Your reference: SSD-10101987

Development Application

Kemps Creek Data Centre (SSD-10101987) 707-769 Mamre Road Kemps Creek NSW 2178, Lots X & Y DP421633 and Lot 22 DP258414

The NSW Rural Fire Service has reviewed the Environmental Impact Statement and provides the following recommendations:

KEY

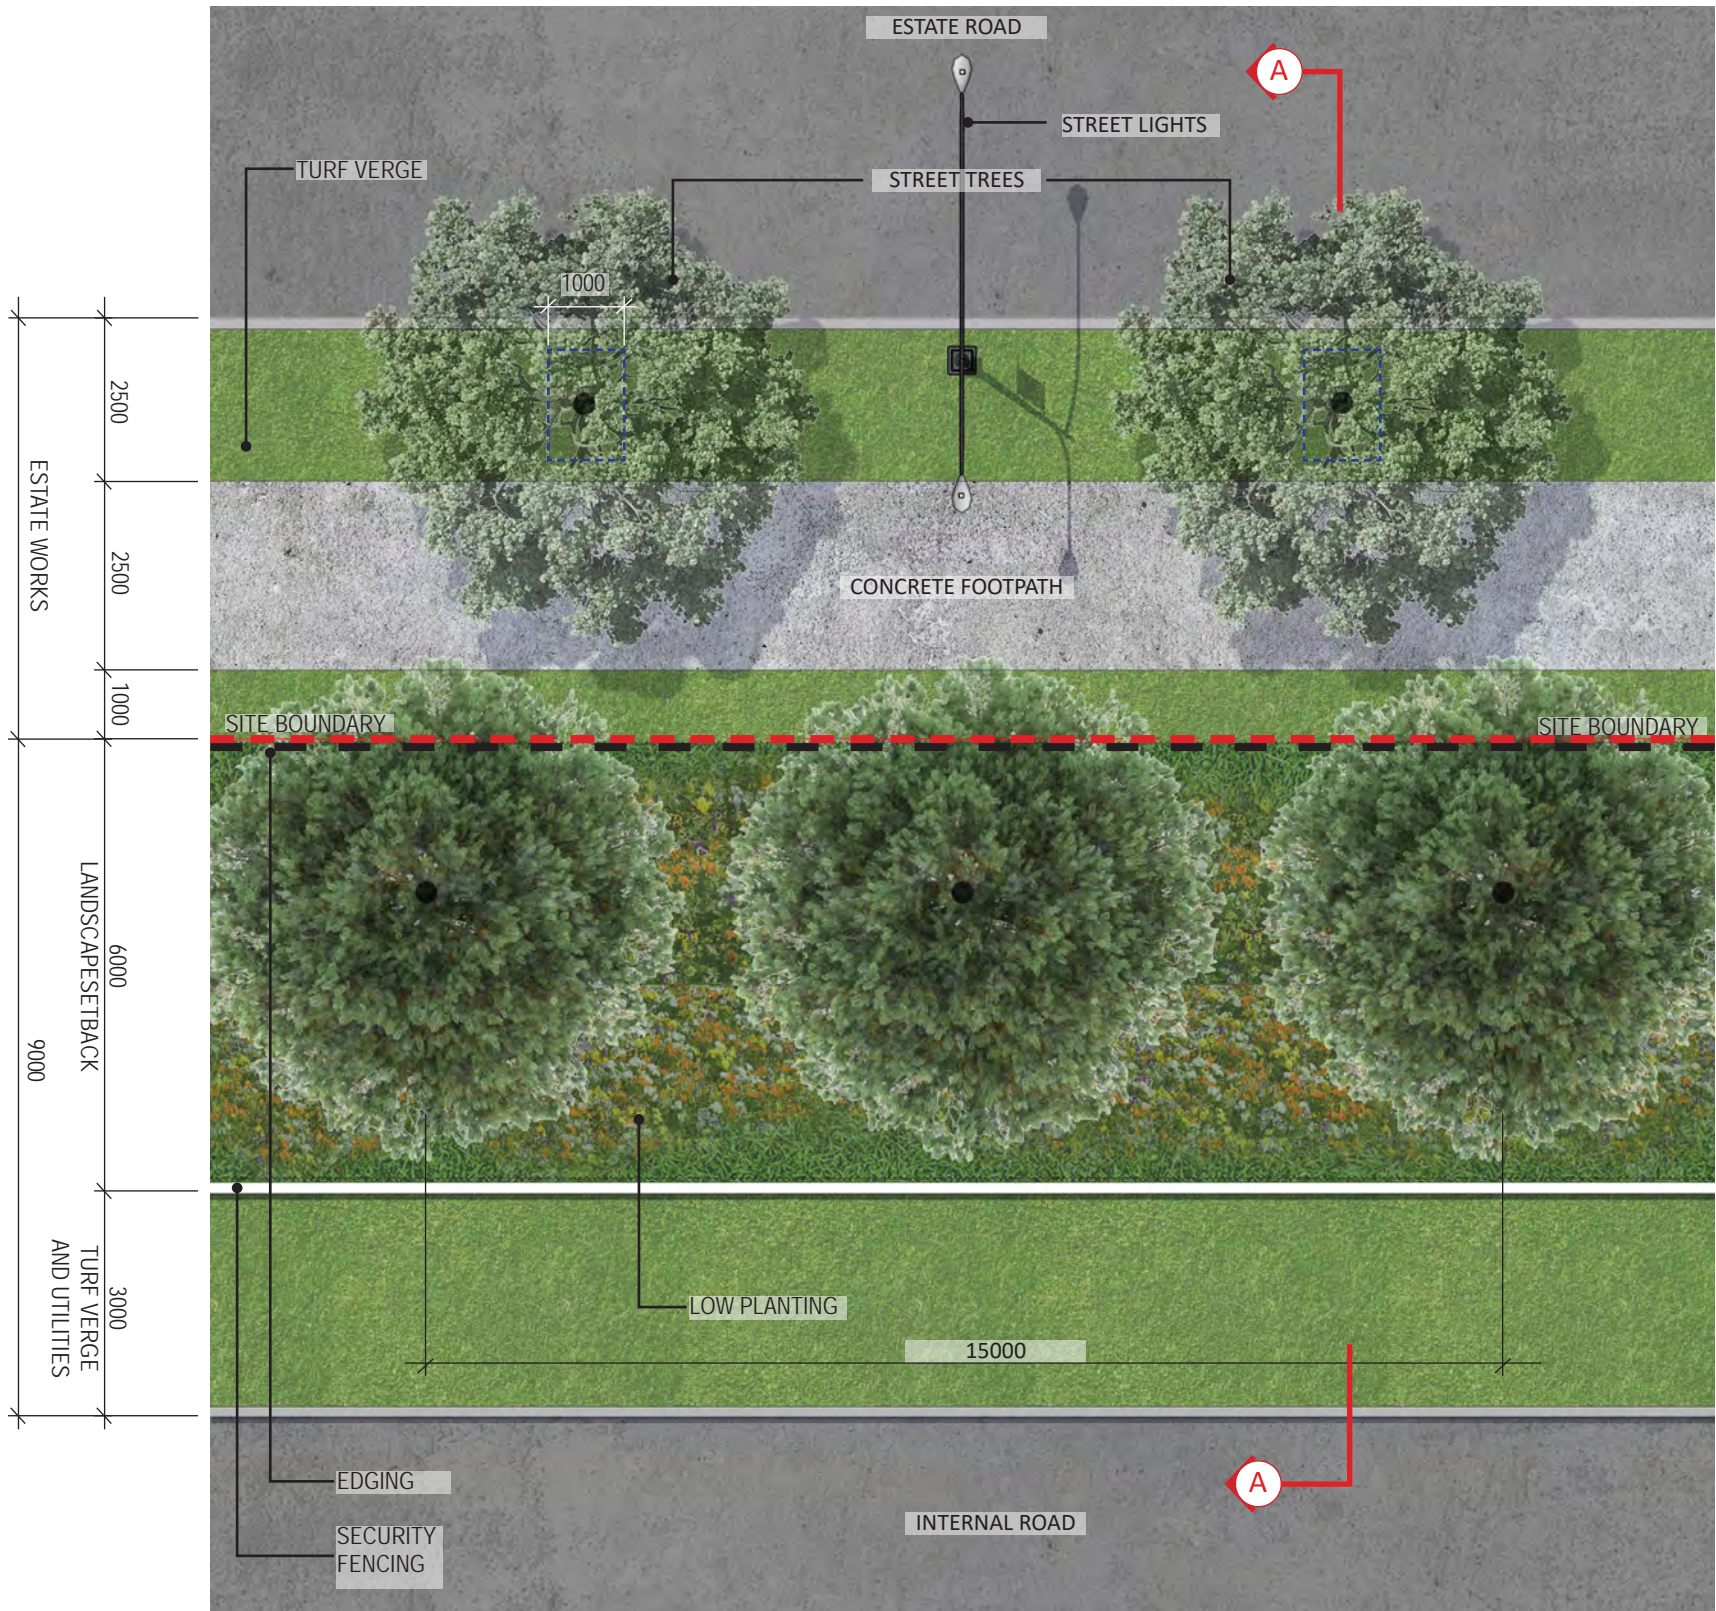
- Leaves and vegetation debris are removed; and
- NSW Rural Fire Service's document Standards for asset protection zones.
- 3. Landscaping within the entire development site of the proposed data centre must comply with Appendix 4 of *Planning for Bush Fire Protection 2019*. In this regard, the following principles are to be incorporated:

- A minimum 1 metre wide area (or to the property boundary where the setbacks are less than 1 metre), suitable for pedestrian traffic, must be provided around the immediate curtilage of the building;

- Planting is limited in the immediate vicinity of the building;
 - Planting does not provide a continuous canopy to the building (i.e. trees or shrubs are isolated or located in small clusters);

- Landscape species are chosen to ensure tree canopy cover is less than 15% (IPA), and less than 30% (OPA) at maturity and trees do no touch or overhang buildings;
